Our ref: RA/2022/145159/01-L01
Your ref: 2022/93154

Date: 06 December 2022

ERECTION OF 68 DWELLINGS WITH ASSOCIATED ACCESS, PARKING, OPEN SPACE, LANDSCAPING AND INFRASTRUCTURE WORKS (INCLUDING INSTALLATION OF SURFACE WATER ATTENUATION TANK) – LAND AT PENISTONE ROAD, FENAY BRIDGE, HUDDERSFIELD, HD8 0AW

Environment Agency position

**FLOOD ZONE NOTES**  
DASHED LINE DICTATES  
CURRENT FLOOD ZONE 2 & 3  
EXTENTS BASED OFF EA DATA

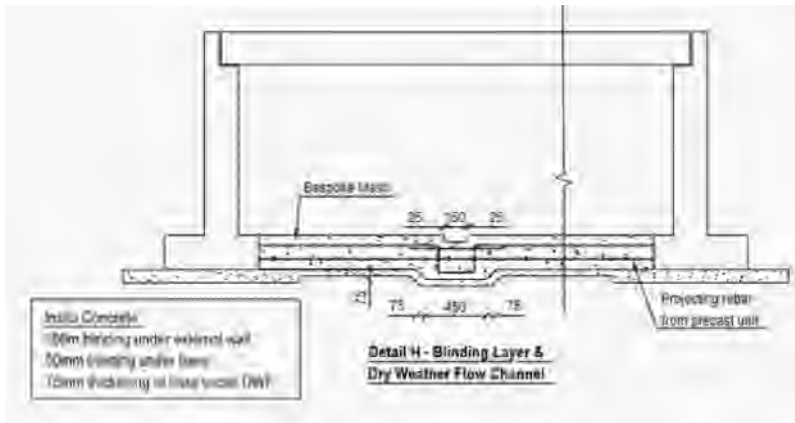
The residential development is entirely within Flood Zone 1. However, the FRA indicates surface water attenuation is required south of Penistone Road. The FRA indicates the attenuation tank is not within Flood Zones 3 or 2. It isn't clear whether the attenuation tank will be above or below ground.

The area of land shown in drawing 'Attenuation Tank Area Plan', reference 101 rev P3 (FRA Appendix E), is close to Flood Zones 2 and 3 and an area of functional floodplain 3b within the red line boundary of the site south of Penistone Road. Flood Zone 3b (functional floodplain) is an area at high flood risk where water would flow or be stored in times of flood. As an indicator of flood risk flood zone 3ai was originally designated by the council as at risk from a modelled 1 in 20/25 year (or 5% probability) this definition has recently changed to a 1 in 30 year (or 3.3% probability) in an update to PPG.

The FRA needs to assess the flood risk to any development on the south side of Penistone Road such as the surface water attenuation tank. The assessment needs to be up to and including the design event ie the 1% (or 1 in 100 year probability) taking into account [climate change allowances](#). The flood zones do not take climate change into account.

The FRA needs to show there is no loss of storage up to and including the 1% plus climate change scenario (design flood level). It would be useful to map this extent on a site plan to show any development in these areas.

The FRA needs to indicate site ground levels pre and post any re-profiling and compare this to the design flood level. Cross sectional drawings may be used to show this does not alter the flood risk to the site, existing flood flow routes or transfer flood risk to others. (Please see further information in the Informatives below).
